Consultee Comments for Planning Application 24/00733/FUL

Application Number: 24/00733/FUL

Address: Porthole Barn Ham Lane Sidlesham West Sussex

Name: Mr Coast Protection & Land Drainage Officer

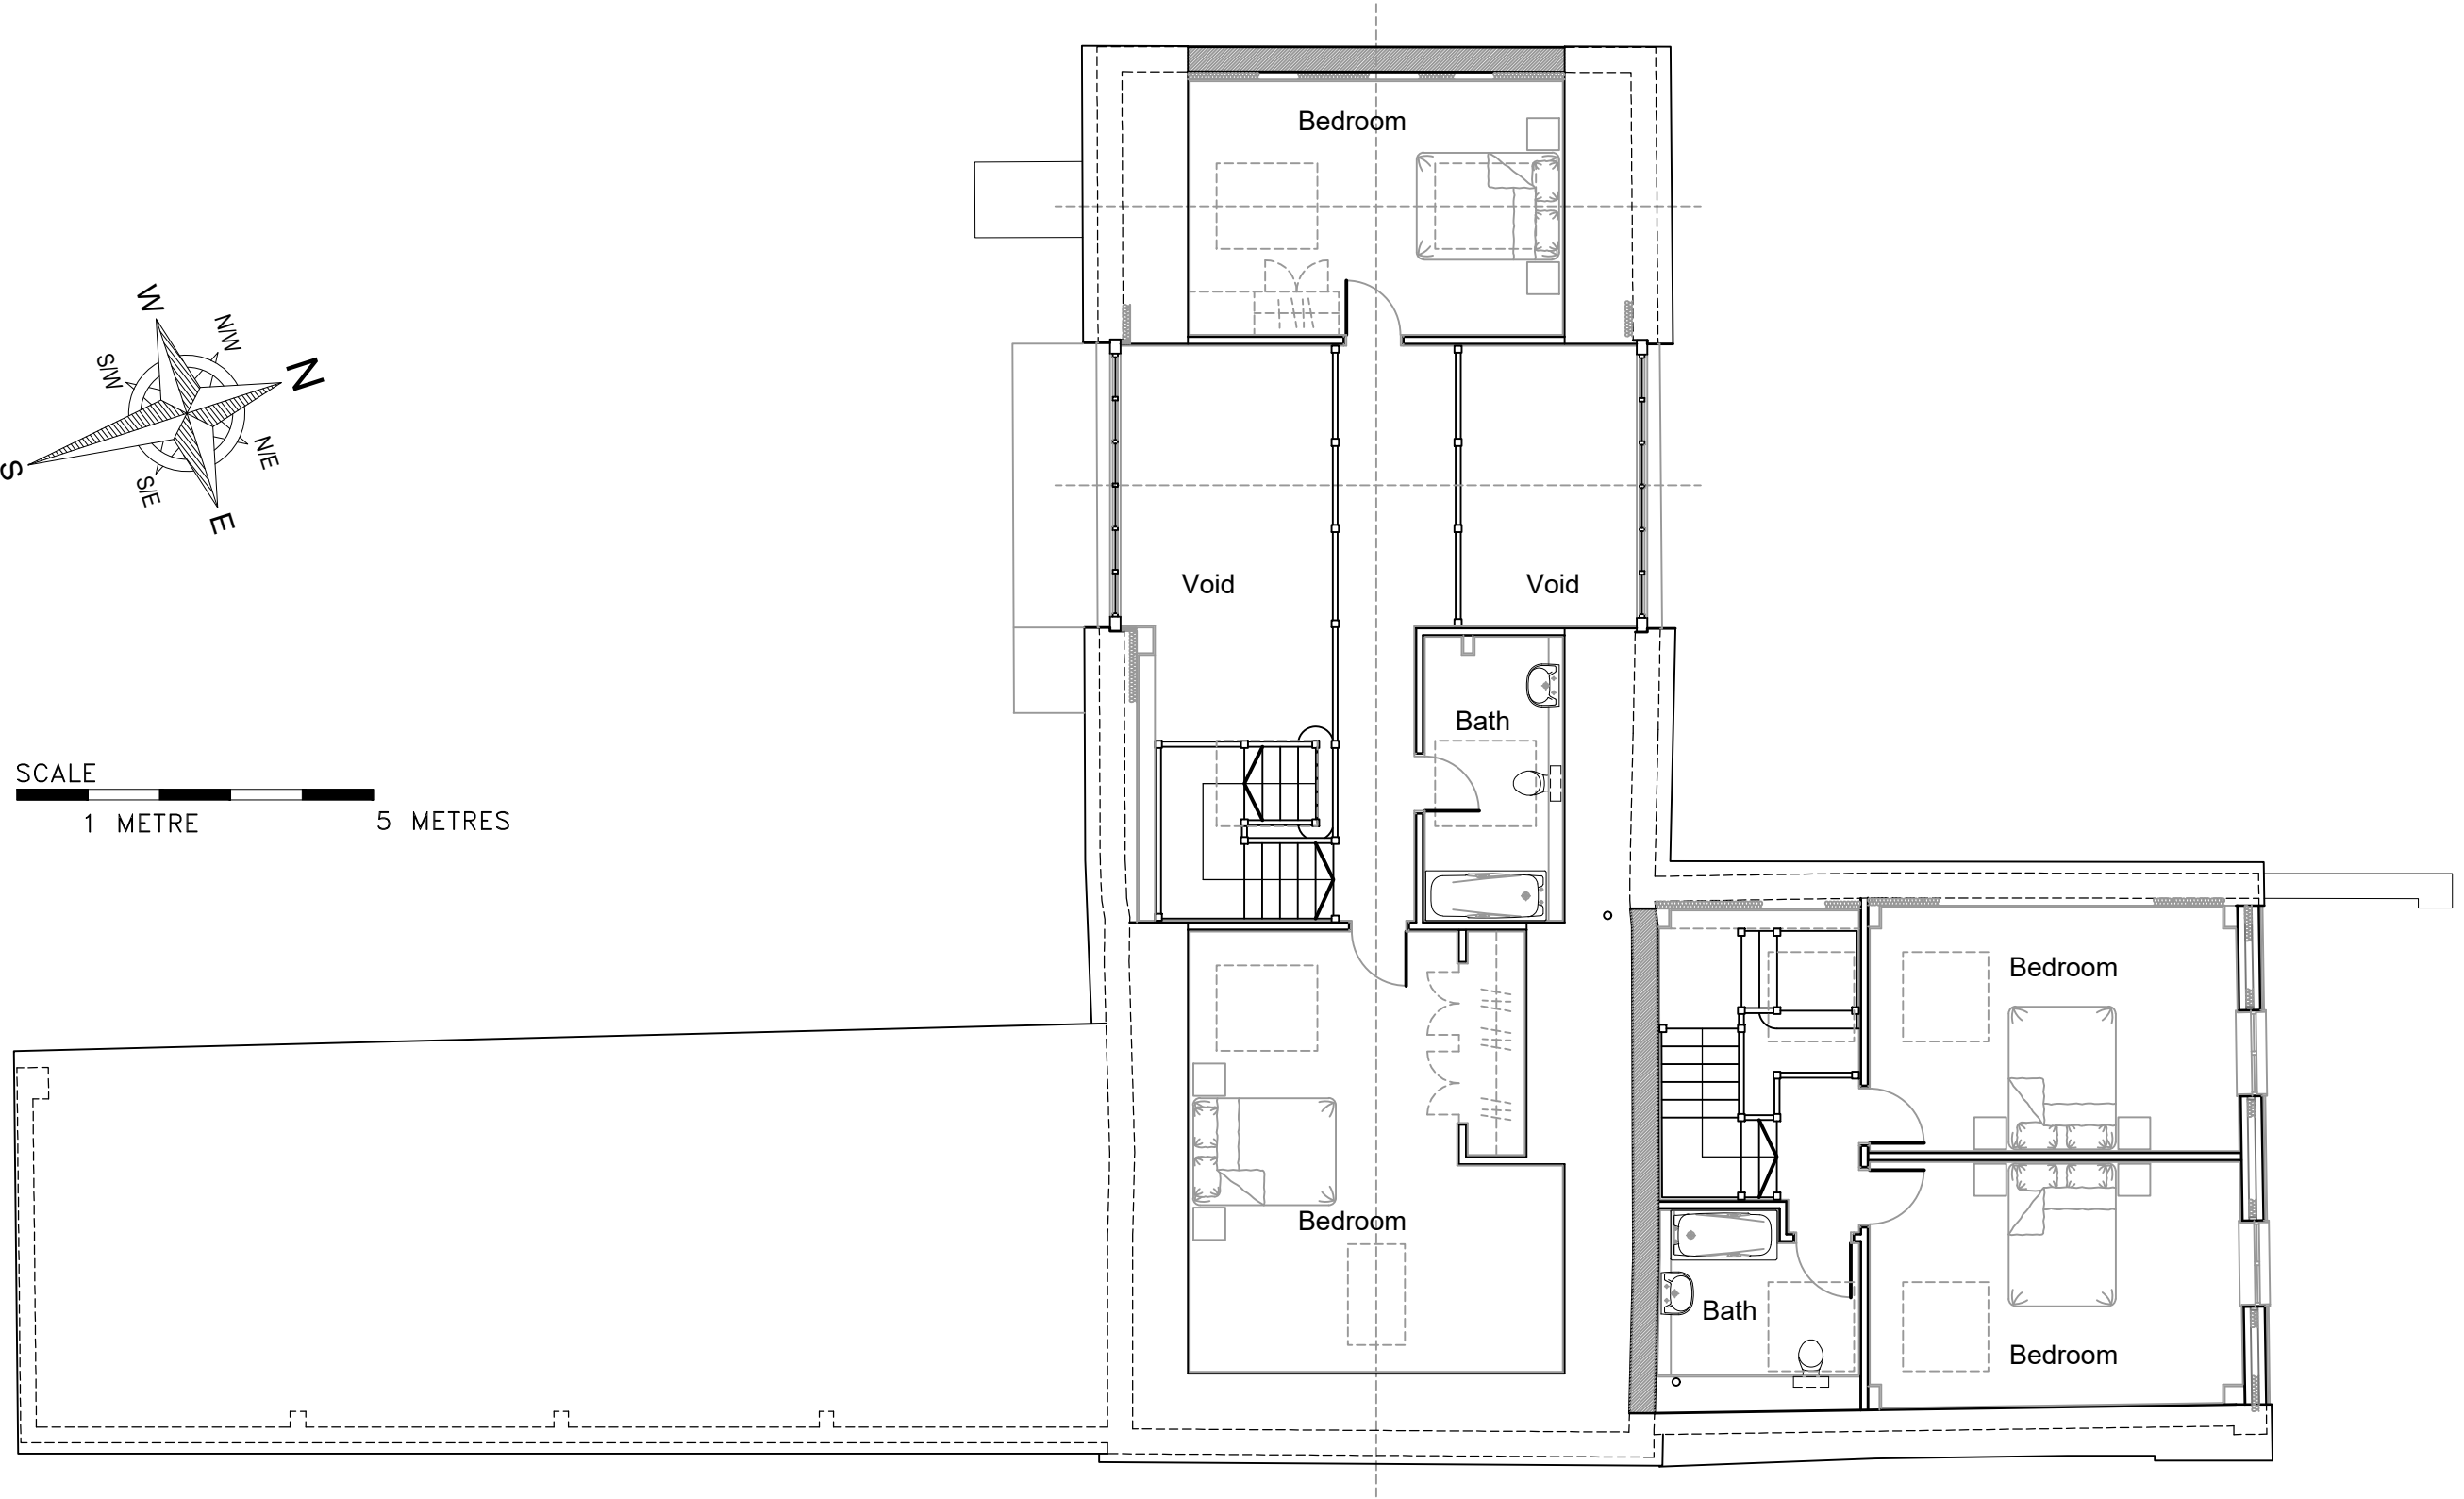
The proposal is for ground FFLs to be raised to a minimum 4.72m AOD, which will be an improvement over the existing floor levels, passively reducing flood risk to the property/occupants. All sleeping accommodation will also be on the first floor. These should be a condition of any approval.

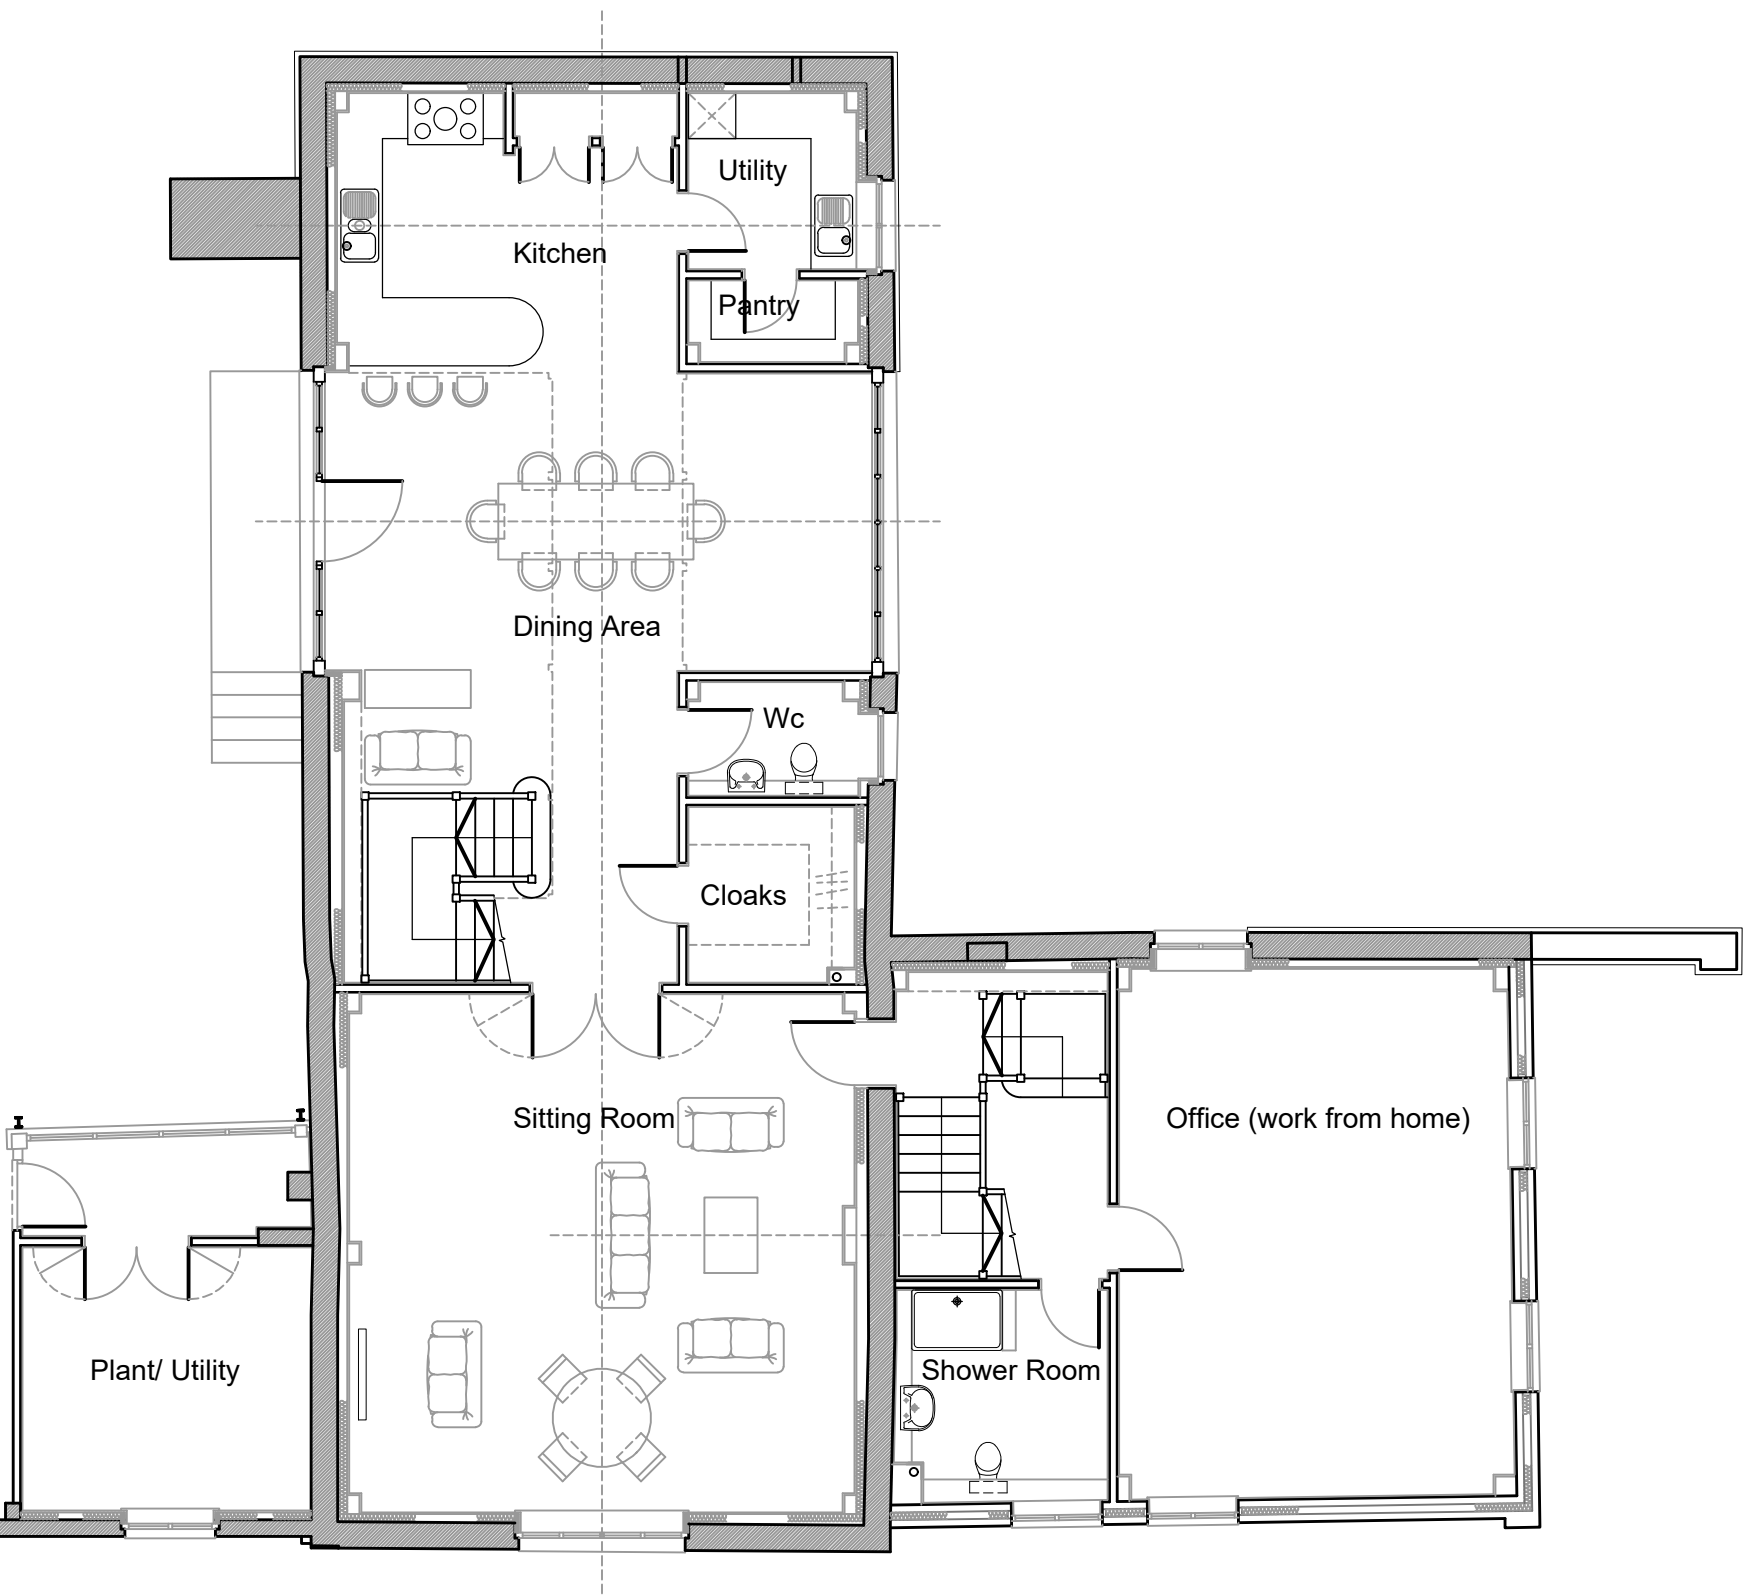
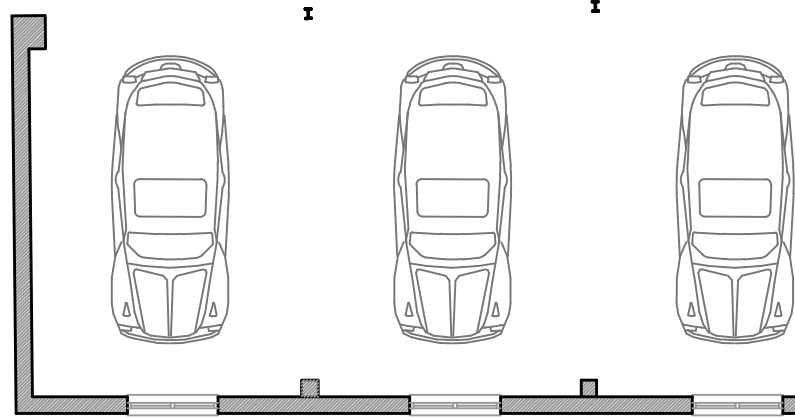
The latest FRA submitted predicts a slightly higher flood level of 4.89m AOD for the 1 in 200 year event in 2021 (lifetime of the development). The applicant may wish to consider whether there is scope to raise the FFLs further to match or exceed this level.
